CITY OF ALBUQUERQUE

Re: Caliber's Shooting Range, 4340 Cutler Ave. NE
Engineer's Stamp dated 12-18-2012 (H-17/D089A)

Based upon the information provided in your submittal received 12-19-12, the above referenced plan cannot be approved for Building Permit until the following comments are addressed:

PHASE 2 GRADING PLAN

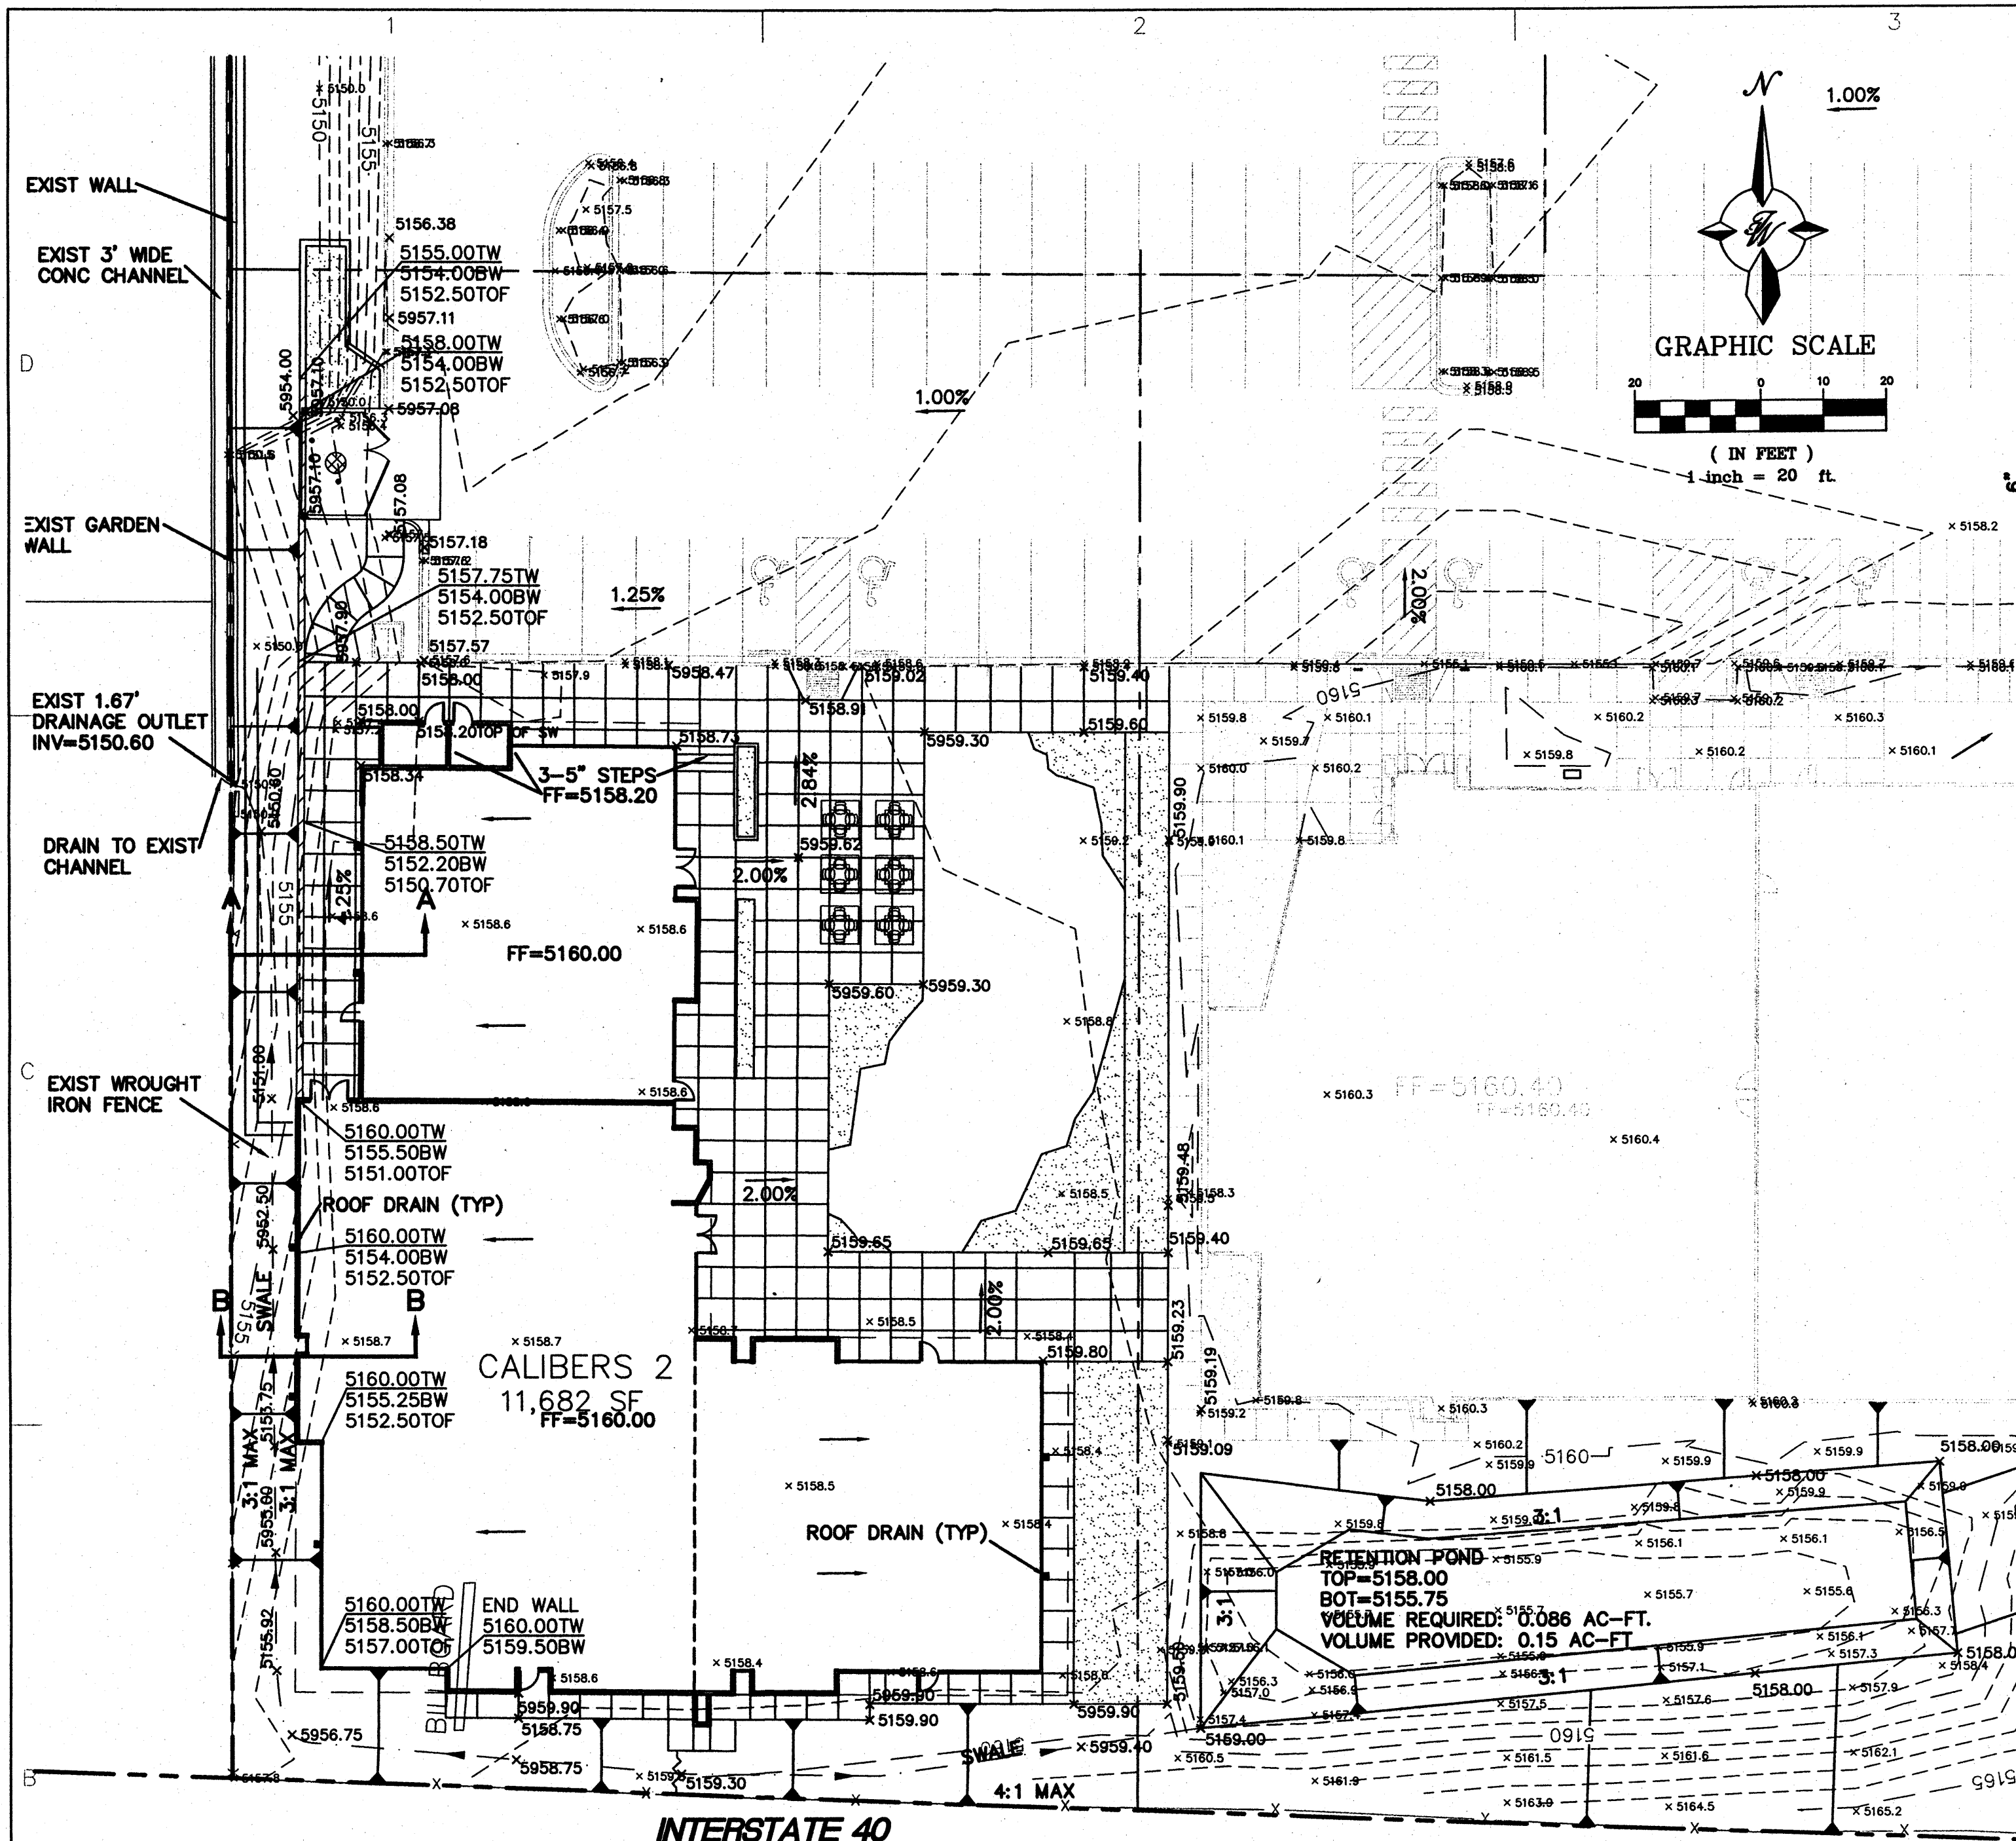
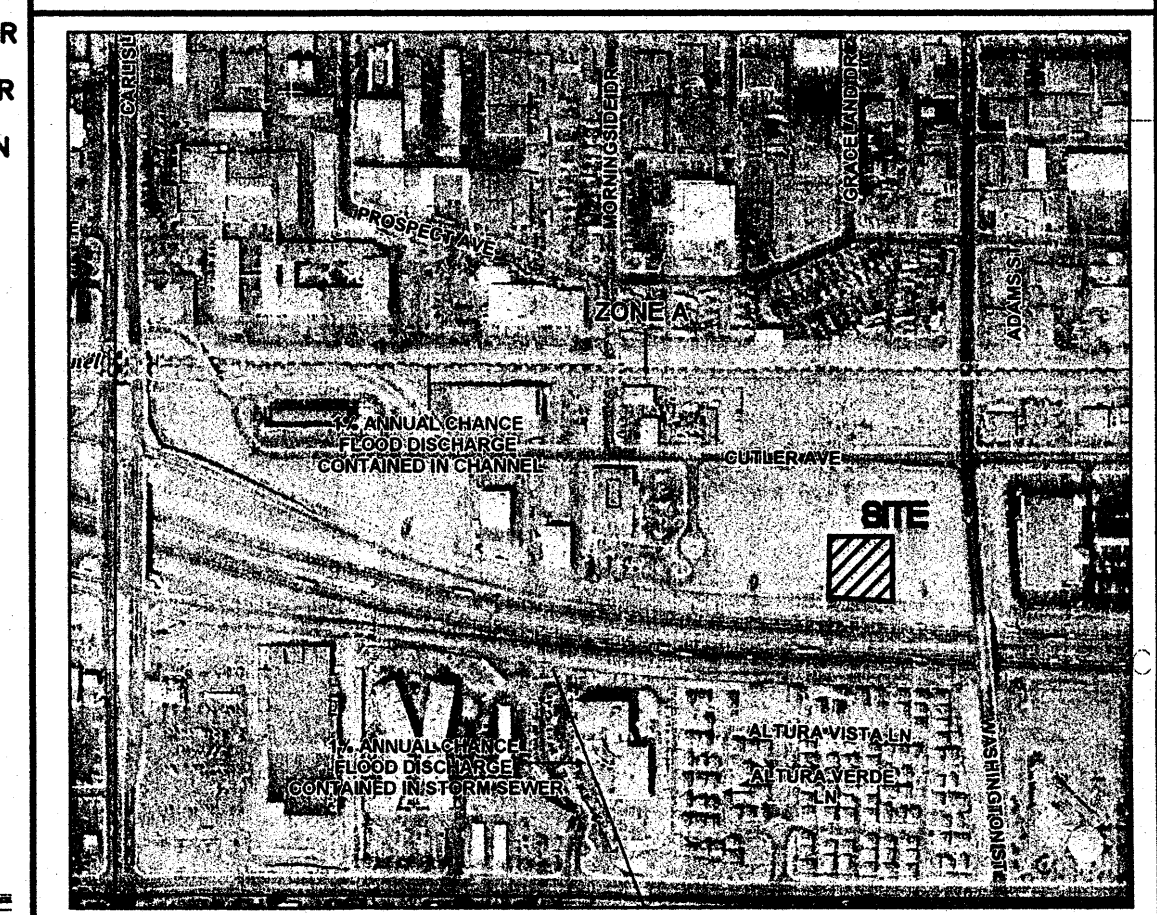
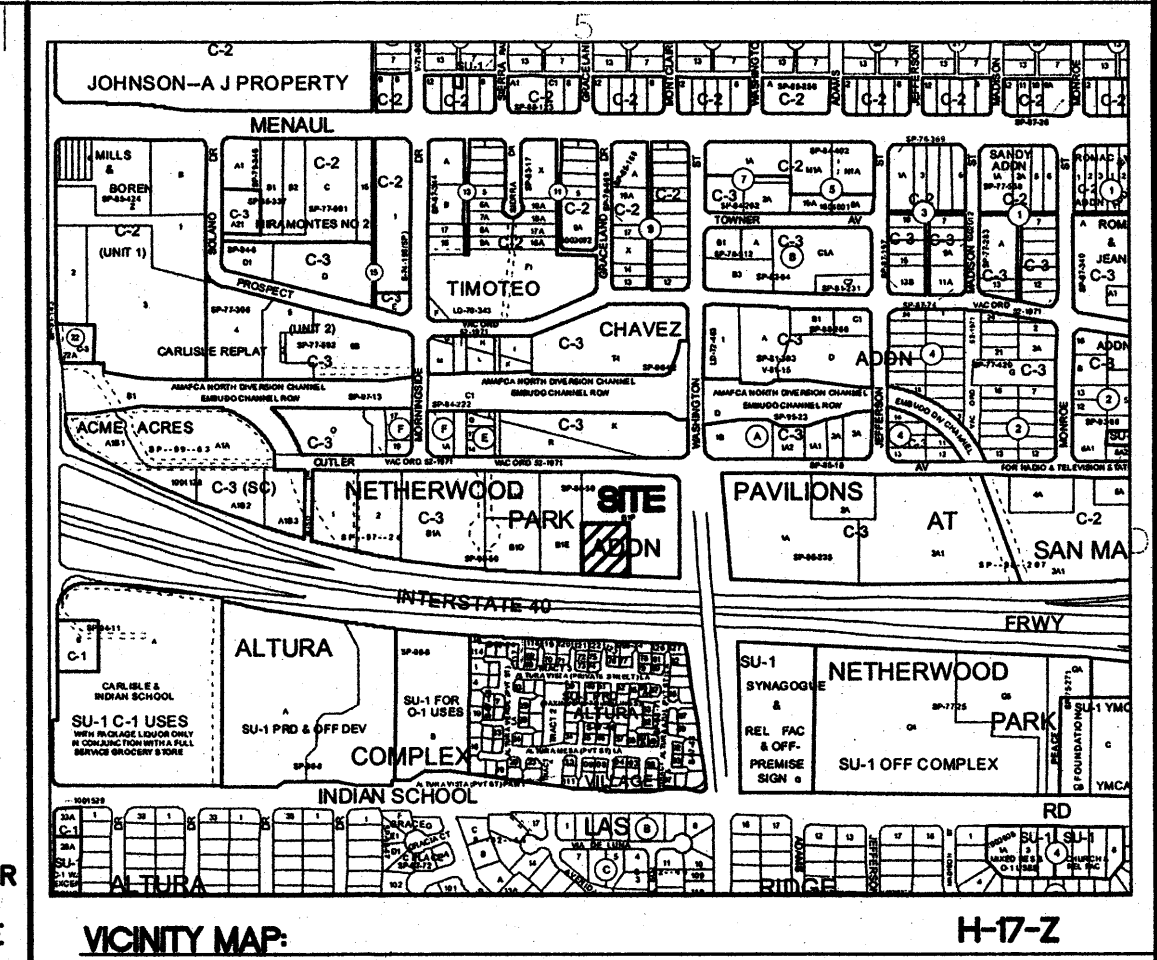
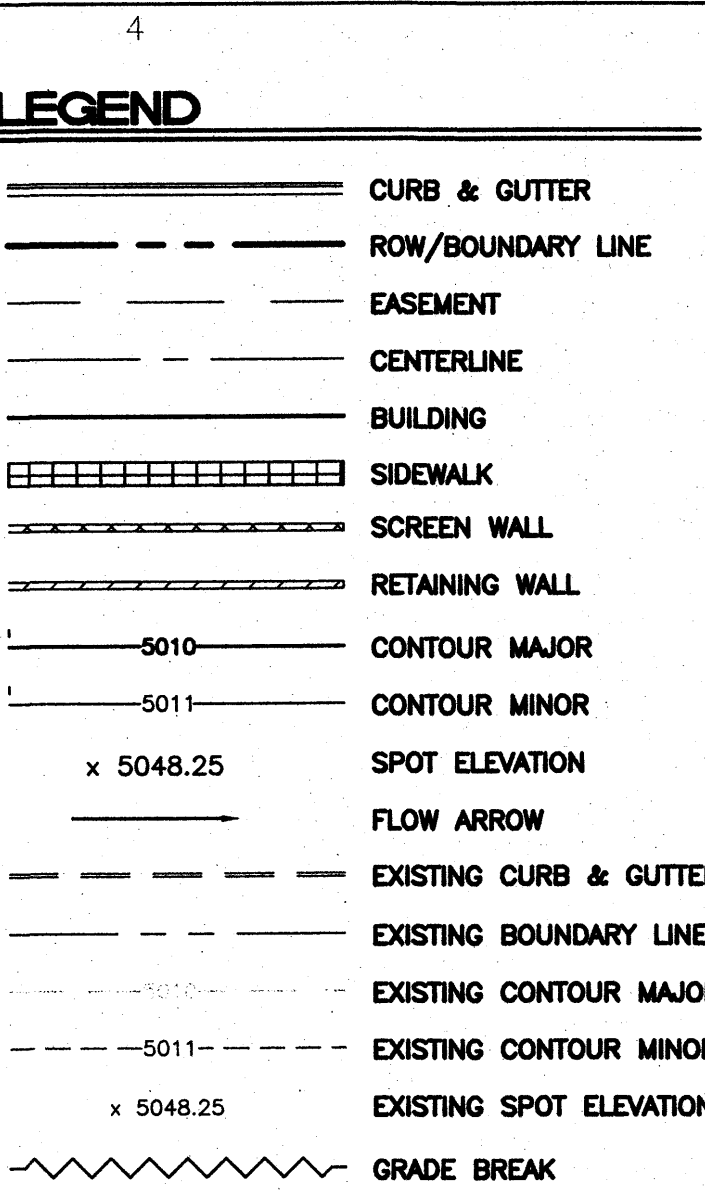
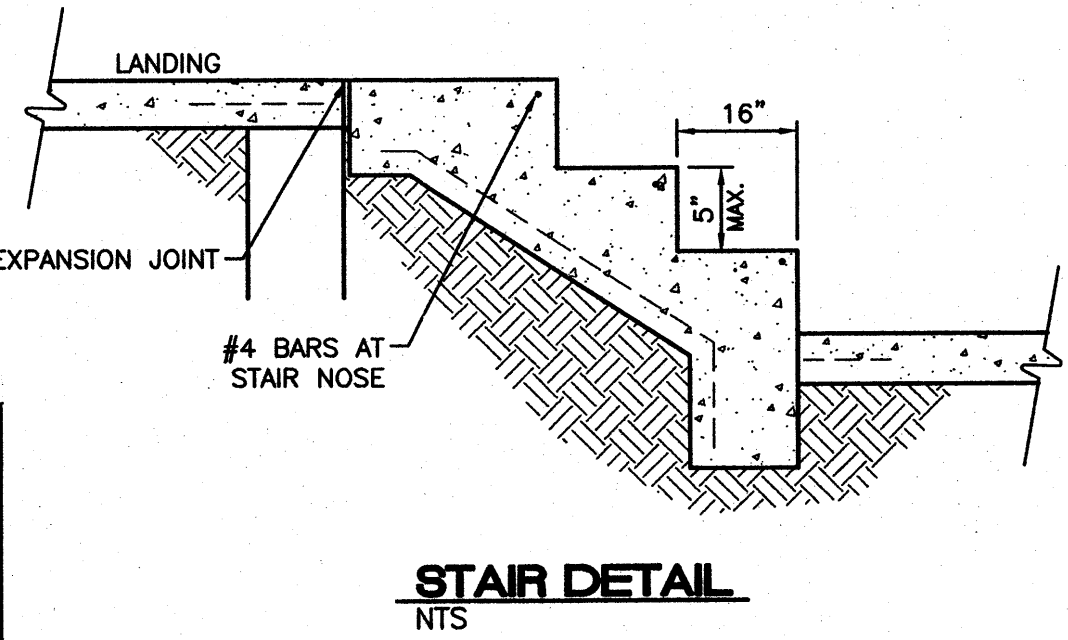
1. The proposed grading and placement of cobbles along the western property line encroaches upon the adjacent lot. A written agreement from this lot's owner will be needed before this work can be approved.
2. The southern swale in Basin 4 appears to be directed in a concentrated flow towards the neighboring property line; will a cobble swale be required at this location as well?
3. Please provide a note or a detail for the proposed 10' cobble swales.
4. A portion of Basin 4 that was originally included in it's calculations along the west entrance to the northernmost building appears to now outfall into Basin 1 and should not be included in Basin 4's flows.
5. Section A-A and B-B might need to be changed based on the response of the adjacent lot's property owner.
